APPROVED
 Limited building only review.
 Permit holder responsible for full compliance with the code.

02/23/2021

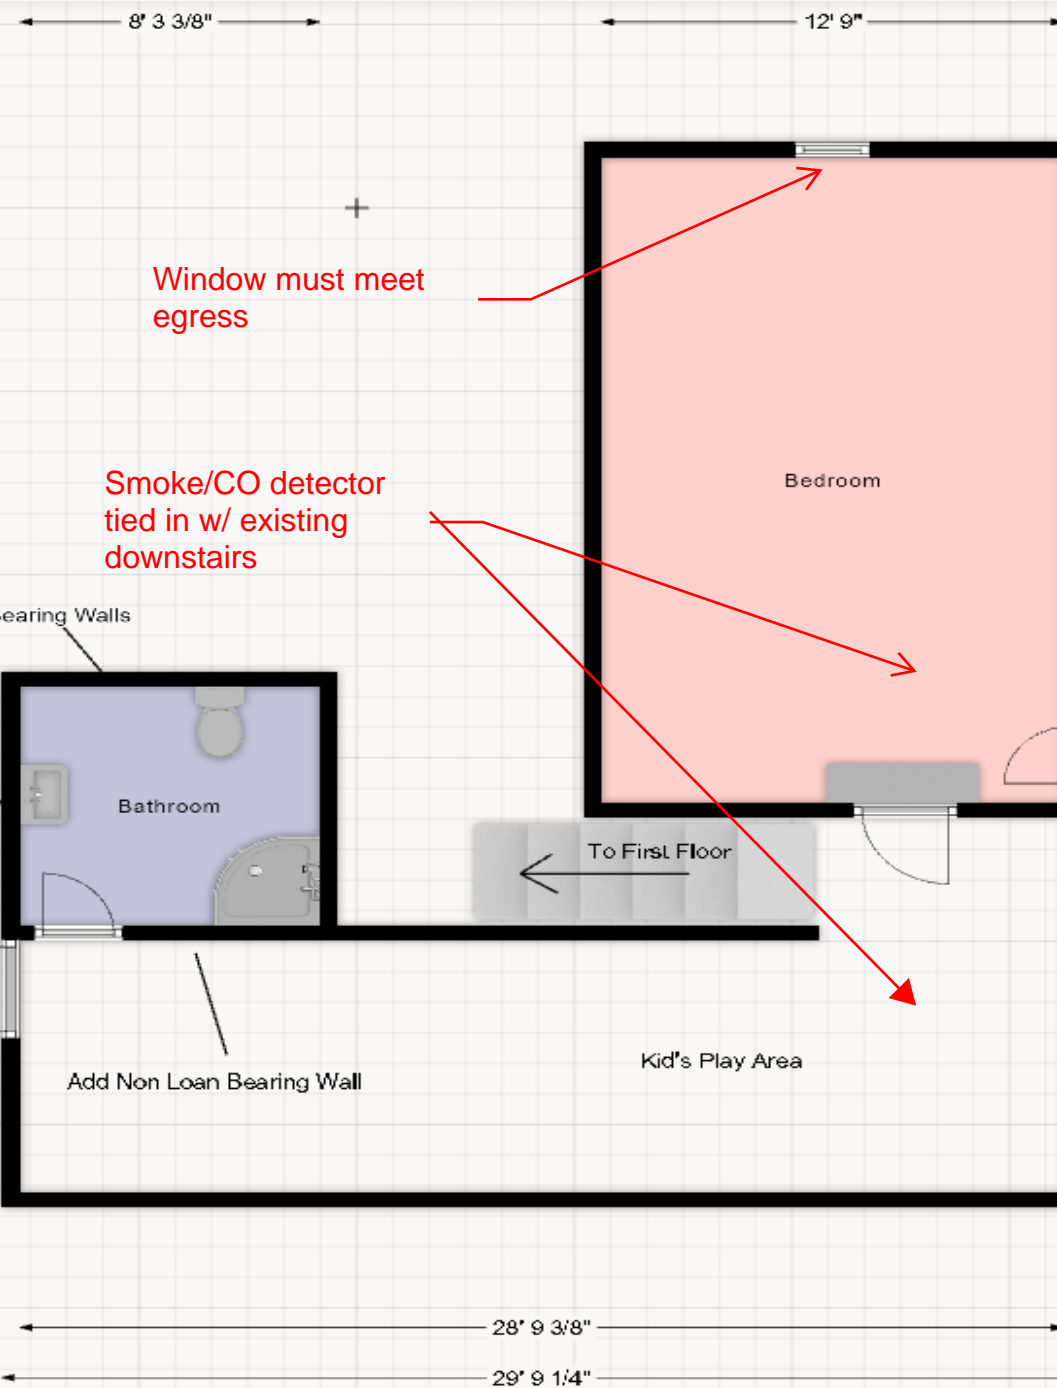
Window Must Meet Egress

Smoke/CO Interconnected with existing
